SHOALHAVEN CITY COUNCIL – PROJECT APPLICATION MP 06_0025 – THE WOOL ROAD & NAVAL COLLEGE ROAD, VINCENTIA – VINCENTIA DISTRICT TOWN CENTRE

Reference is made to the recent meetings where both Council and Stocklands have met separately with Roads and Maritime Services (RMS) regarding road infrastructure requirements for the subject development proposal. These meetings were held to discuss Stocklands request to replace an existing condition of consent which requires construction of a pedestrian underpass on Naval College Road (immediately north of the intersection with the Wool Road) with mid-block pedestrian signals on Naval College Road.

Wool Rd x Naval College Rd
2016 Thurs PM Peak
Roundabout

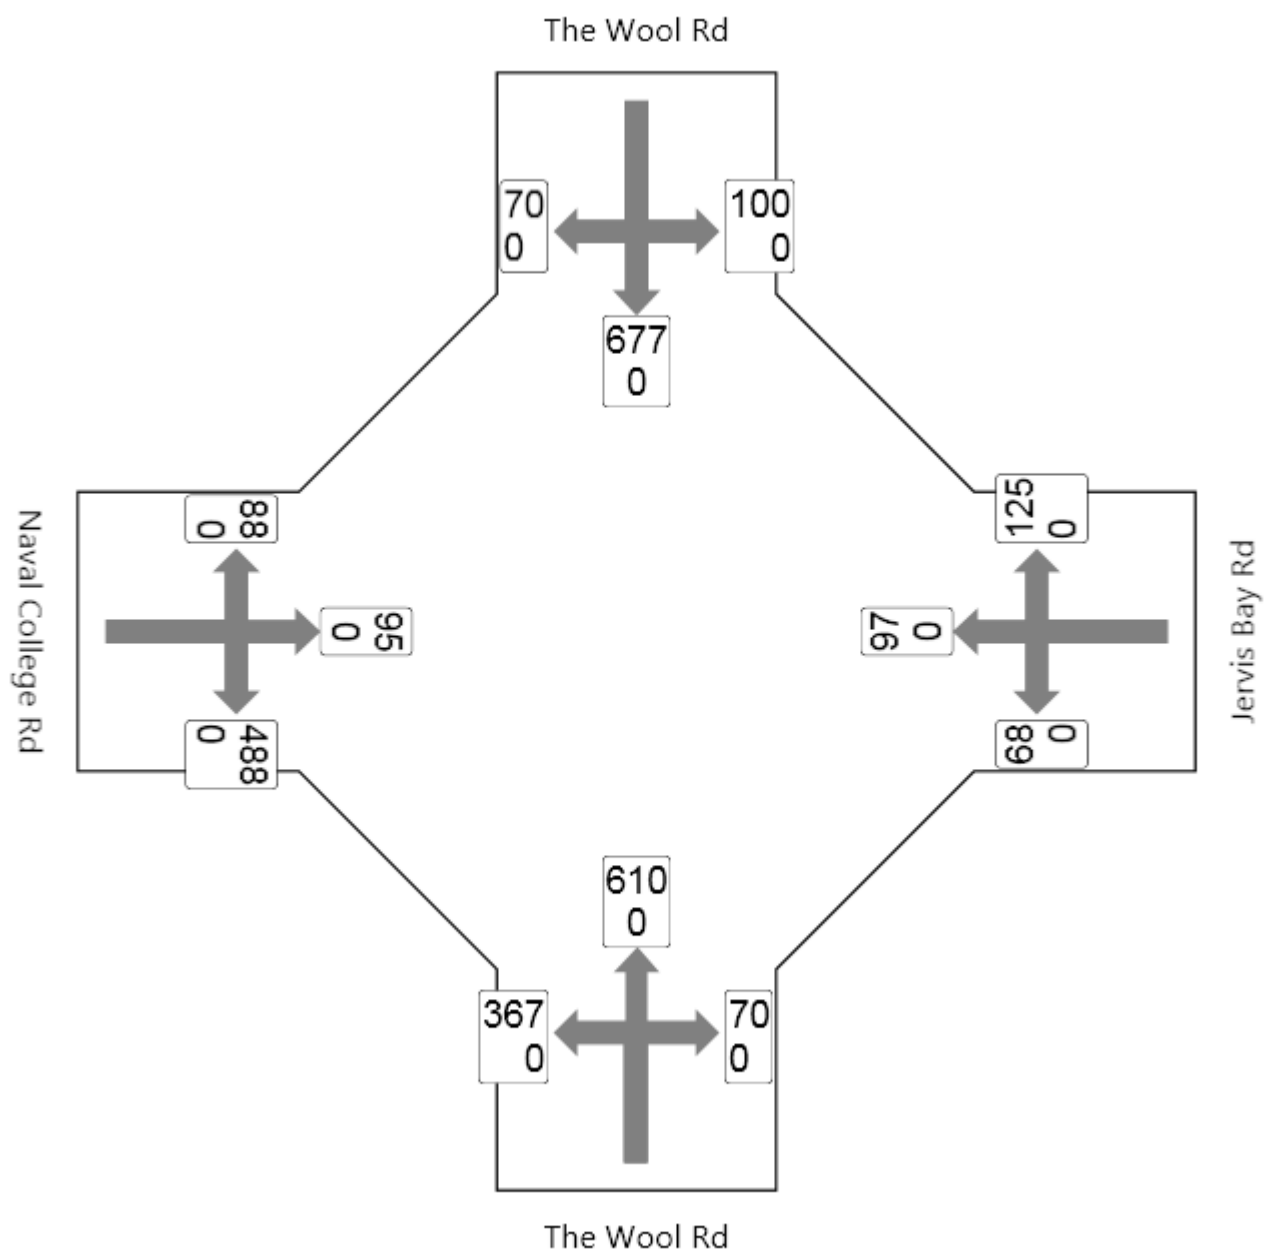
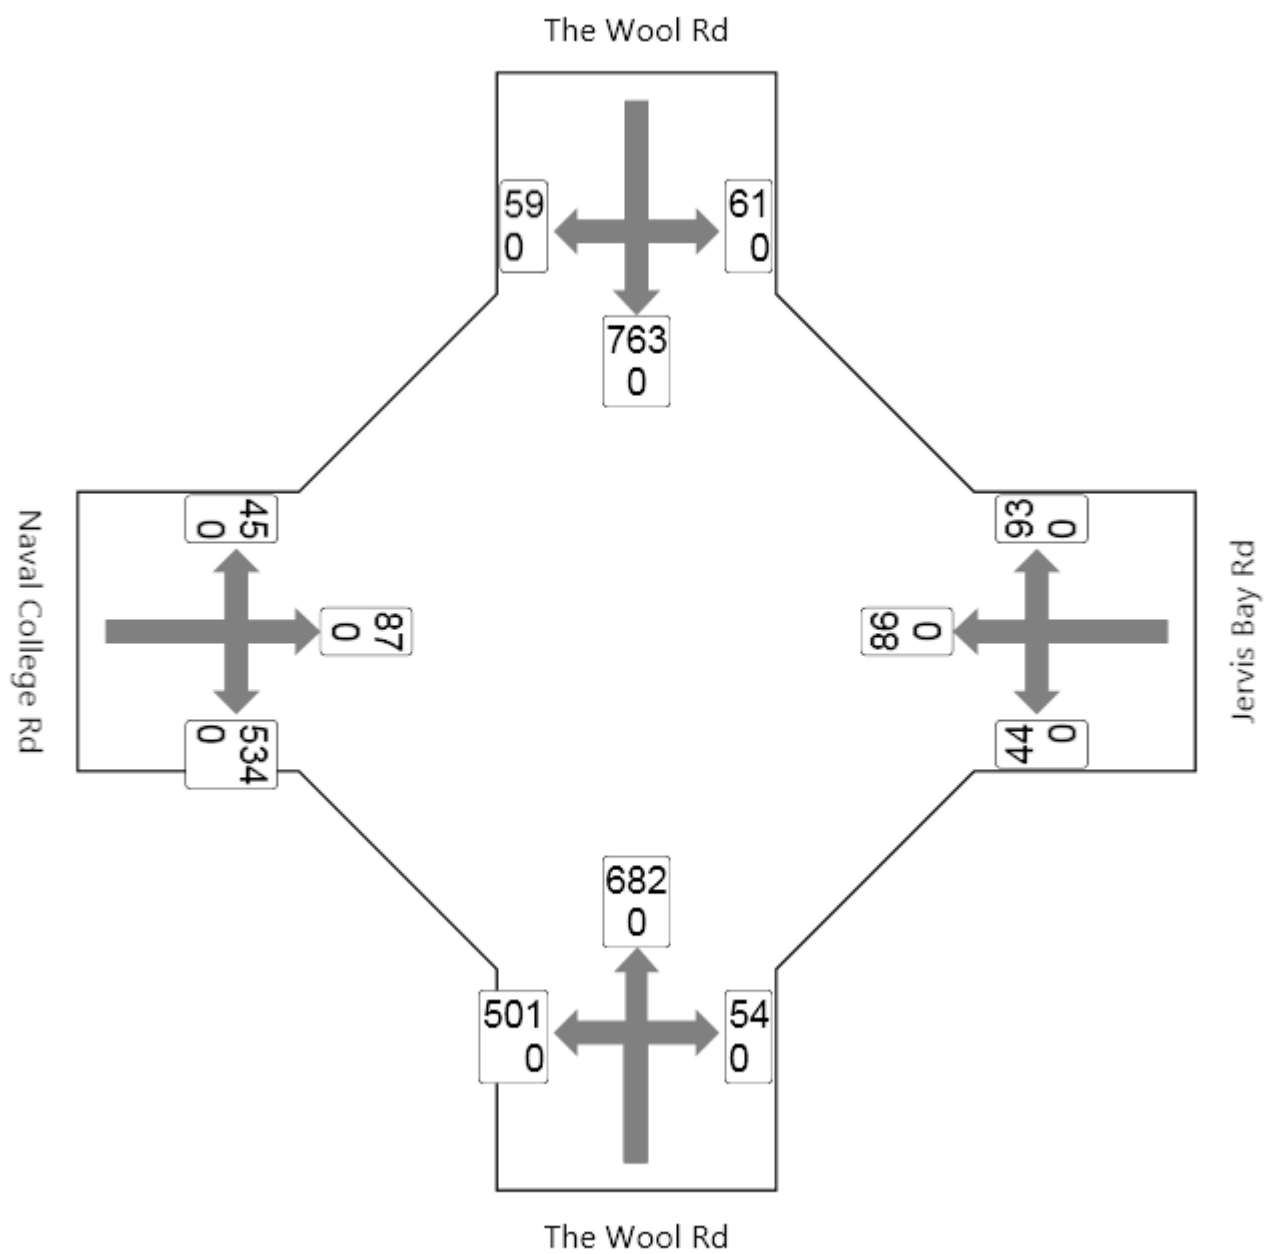
- Signalising the intersection of Naval College Road and the Wool Road would address this desire line and remove the need for mid-block traffic signals. RMS notes the requirement for the proponents to upgrade the intersection of the Wool Road and Naval College Road to a two lane roundabout. RMS also notes the requirements for the proponents to construct two signalised intersections on the Wool Road northeast of Naval College Road and for a separate developer to

- RMS is concerned that whilst these intersection treatments may operate well in isolation, they may not operate well as a group of intersections. In this regard, whilst RMS recognises that extensive modelling was undertaken using SIDRA to verify the suitability of the arrangements, RMS considers that network modelling is the most appropriate way to consider signalised and roundabout controlled facilities in such close proximity to one another.

- On this basis, RMS would support further investigation to explore the provision of traffic signals at the intersection of the Wool Road and Naval College Road in lieu of the requirements to upgrade this junction and provide a pedestrian crossing facility across the northern leg on Naval College Road. RMS would recommend modelling the surrounding network using Paramics, to include coordination of this intersection with surrounding traffic signals, from the proposed Anglican School to the Stocklands Development and Vincentia High School to the north-east on the Wool Road. RMS considers that any further modelling should be based on Council's projected traffic volumes.

If Council is not willing to reconsider the proposed network arrangements or the proponents are not willing to undertake network modelling to explore the signalisation of the Wool Road and Naval College Road through PARAMICS modelling, RMS accepts that a two lane roundabout will be provided at the intersection of the Wool Road and Naval College Road. In this case, RMS would not object to mid-block traffic signals provided Council is satisfied that the proposed arrangements will adequately address pedestrian desire lines. The mid-block signals would need to be located at Council's preferred location approximately 50m to the north of the developer's proposed location. A formal modification to the existing consent would need to be submitted. However, RMS strongly encourages Council and the proponents to consider alternative options.
